From: lindsey.lucas@hertfordshire.gov.uk
Sent: 19 March 2013 11:48
To: Planning
Subject: Planning application S6/2013/0411/FP - Nolita Restaurant, Great North Road

Response to Planning application from Hertfordshire County Council (T and CP GDP Order 1995)

District ref: S6/2013/0411/FP
HCC ref: WH/60/2013
HCC received: 11/03/2013
Area manager: James Dale
Case officer: Lindsey Lucas

Nolita Restaurant, Great North Road
Hatfield

Brand			
B.U.N. No.			
Site	Nolita Potters Bar		
Title	Proposed Site Plan		
Project Manager/Drawn By	DH	Scale	Date
		1:20 & 1:100	Feb 13
Arch. Des. / Drawing Number	3380/203	Rev.	A

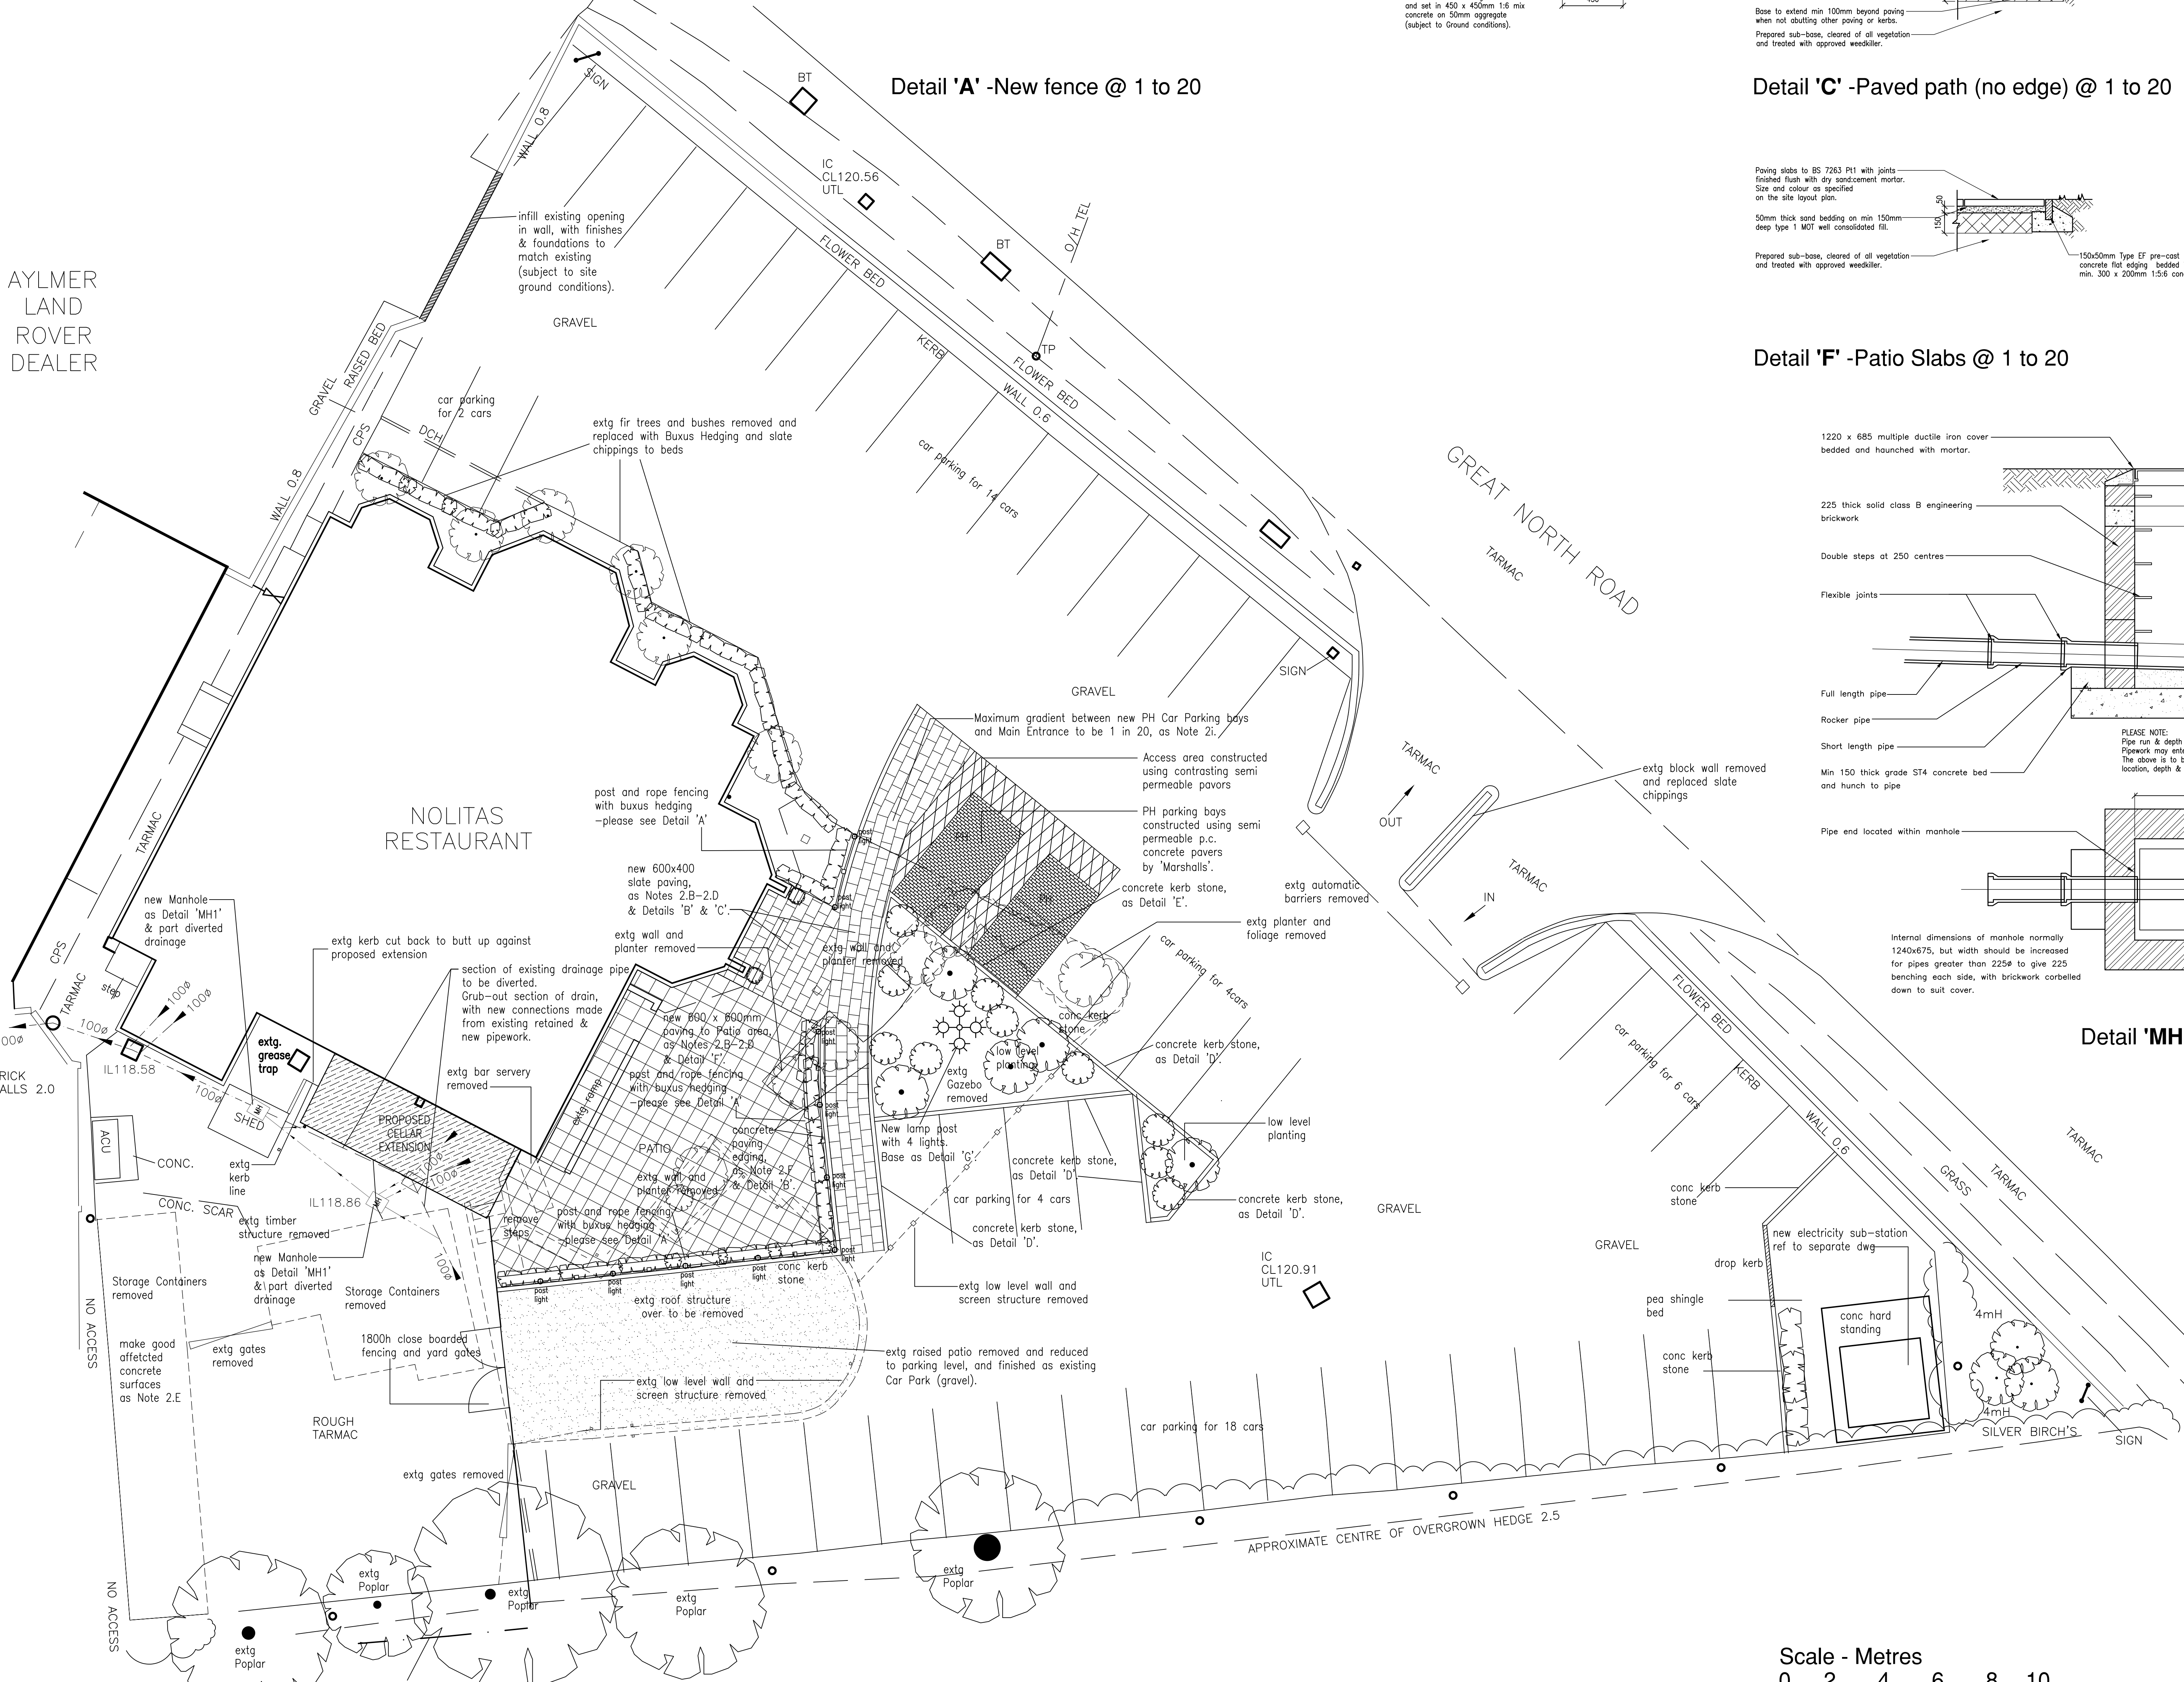
1. Prior to first occupation of the development the associated car parking shown on approved plan 3380/203 Rev A shall be laid out and used for no other purposes. Reason: To ensure the development makes adequate provision for the off-street parking and manoeuvring of vehicles likely to be associated with its use. 2. C8.13 - No unbound material shall be used on the proposed access within 20 metres of the highway boundary. Details of the proposed surface dressing shall be submitted to and agreed in writing by the local planning authority, prior to the commencement of the development and implemented in accordance with those details

banqueting room to part of the restaurant. The site plan 3380/203 rev A shows a car parking layout and I would recommend that prior to occupation of the development the car parking is laid out as shown to ensure that the best use is made of the available space and that turning space is maintained to enable vehicles to enter and leave the site in a forward gear. The site plan shows the parking area being surfaced in gravel and therefore I have added a condition regarding the use of such materials near the highway entrance. Great North Road is a classified road, A1000, a principal road and designated as a main distributor. This section of road is subject to a 50mph speed restriction. There are no proposals to alter the access arrangements and trip generation is unlikely to change. Hertfordshire County Council as Highway Authority considers the proposal would not have an unreasonable impact on the safety and operation of the adjoining highways subject to the
